**FAIRCLOTH - GARAGE  
5244 COOL SPRINGS RD  
BROADWAY, NORTH CAROLINA**

**FOUNDATION PLAN**

**ENGINEERED SUBMITTAL**  
 This submittal has been reviewed for specified design criteria & compatibility with building structure. The design of these components is the responsibility of those providing the components.  
 HMHendrick Enterprises, Inc.  
 By: **HMH** Date: **09/30/25**

**Johnny Faircloth**  
**Garage**  
**ROOF PLACEMENT PLAN**

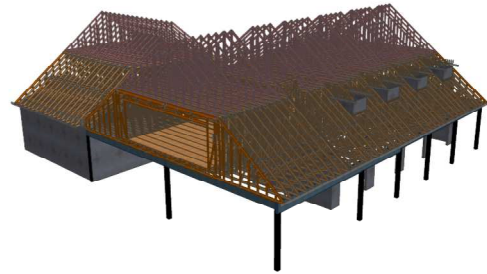
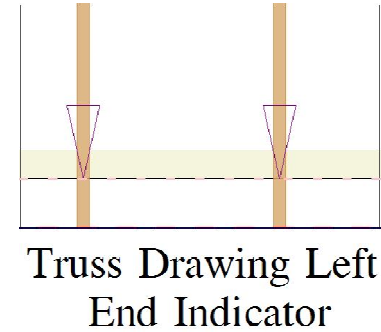
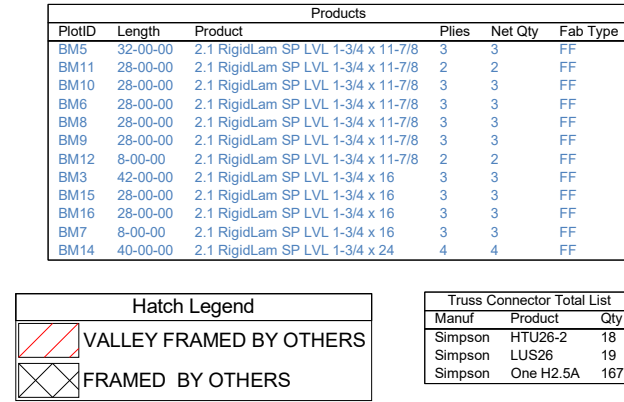
Extend length of building 5'-5" overall to accommodate additional braced wall length between garage bays. no impact to individual truss design, just need to adjust total quantity, (+ 3 trusses)

SET UP 5-08 HEEL HEIGHT AND 12" CANTILEVER (INCLUDE FASCIA) AT THE FINISHED BRICK WALL. PLEASE VERIFY.

USED 5-08 HEEL HEIGHT AND 1-04-00 CANTILEVER FOR ROOF TRUSS SYSTEM. PLEASE VERIFY.  
 PLEASE VERIFY ALL SIZE BEAM LVL AT PORCH AND HEADER GARAGE DOOR FOR THIS JOB.  
 ALL DIMENSIONS ARE FROM OUT FACE OF STUD TO OUT FACE OF STUD.

Truss package engineering package as prepared by Carter Lumber, and sealed by their engineer, (Mr. Eric A. Gilbert, PE) was reviewed for compliance with building layout and assumed loading/load-path, and found to be acceptable for the intended construction.

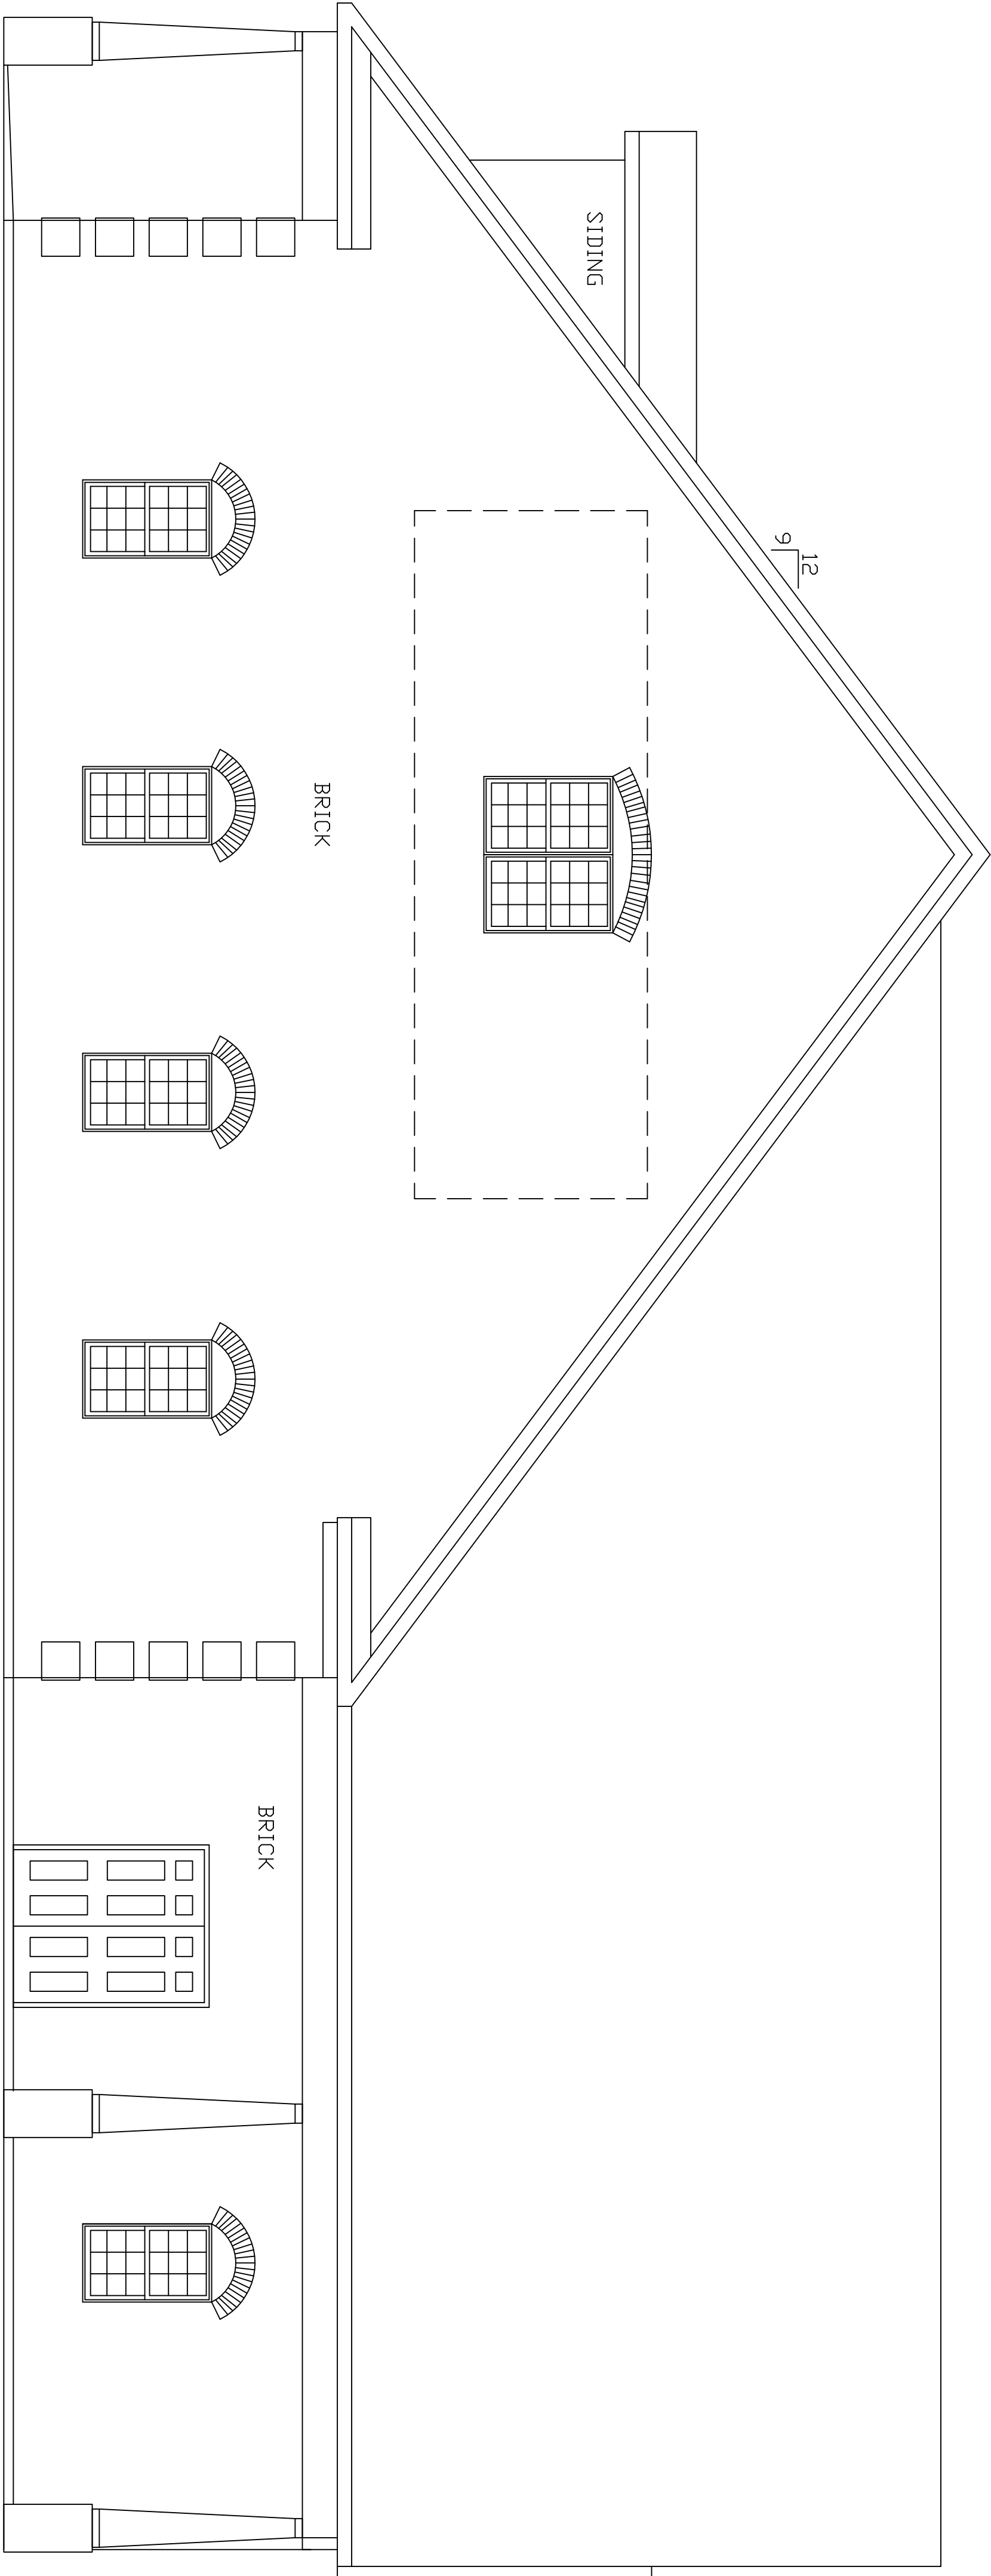
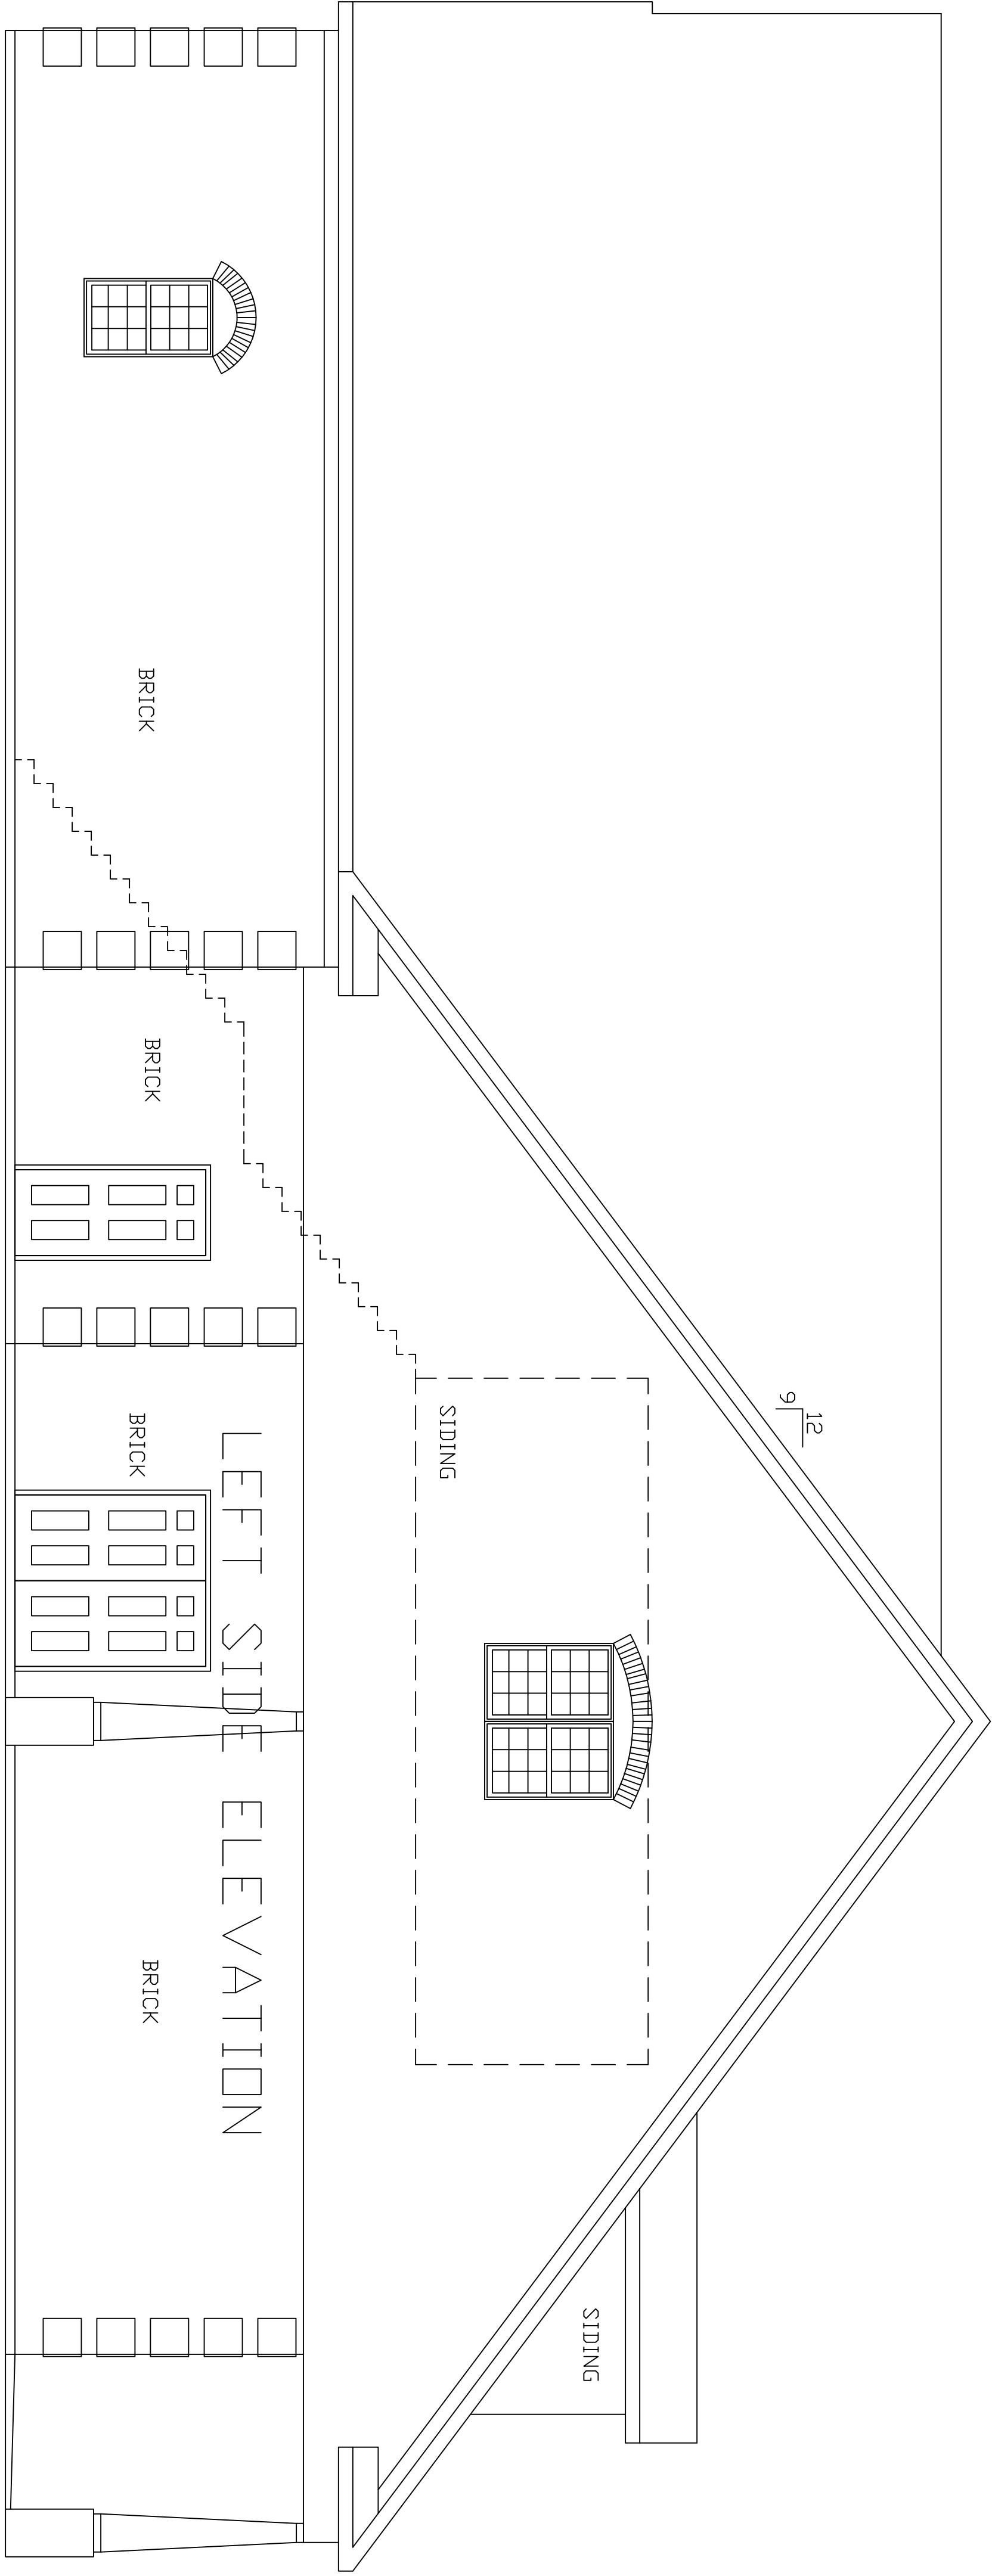
See revised dims provided on  
 foundation plan to accommodate  
 48" braced wall/ portal frame  
 between adjacent garage door  
 openings, typ.
